25 October 2022

610.19382-L03-v1.0-20221025.docx

## Waste Area Size and Configuration Telopea Stage 1A

Figure 3 General waste room and bulky waste storage area

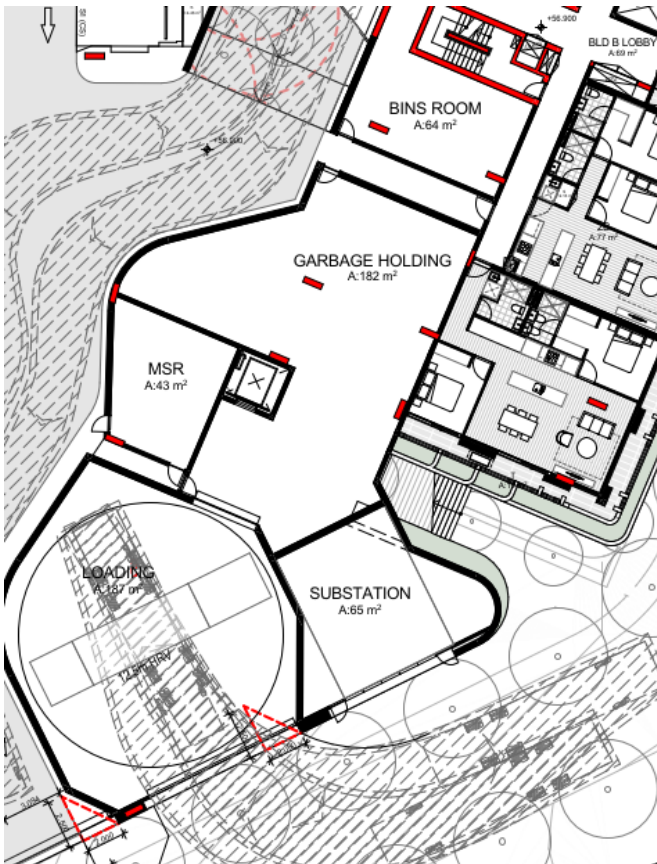
The development has provided for a recycling capacity of 40 L per dwelling per week. This should be 60 L per dwelling per week.

The location of the bulky waste room is not acceptable. The proposed location presents an operational challenge where bulky waste will need to be navigated passed bins in the garbage holding area as bulky waste is collected on the same day as the garbage and recycling bins. The bulky waste room requires a separate access and not through the garbage holding room.

Recycling quantities and bin numbers have been recalculated as shown in Table 1 below.

As outlined in Table 1 above, assuming the use of 660 L bins, a minimum of 54 will be required for garbage and 41 for recyclables, making a total of 95 bins for the development.

The area required will be 167 m<sup>2</sup>. Figure 1 below shows that the waste and recycling storage area is 167 m<sup>2</sup> which is adequate for the proposed number of bins.

The waste and recycling storage area and bulky waste storage area have been reconfigured so that both have separate access to the loading area. This is shown in Figure 1 below.
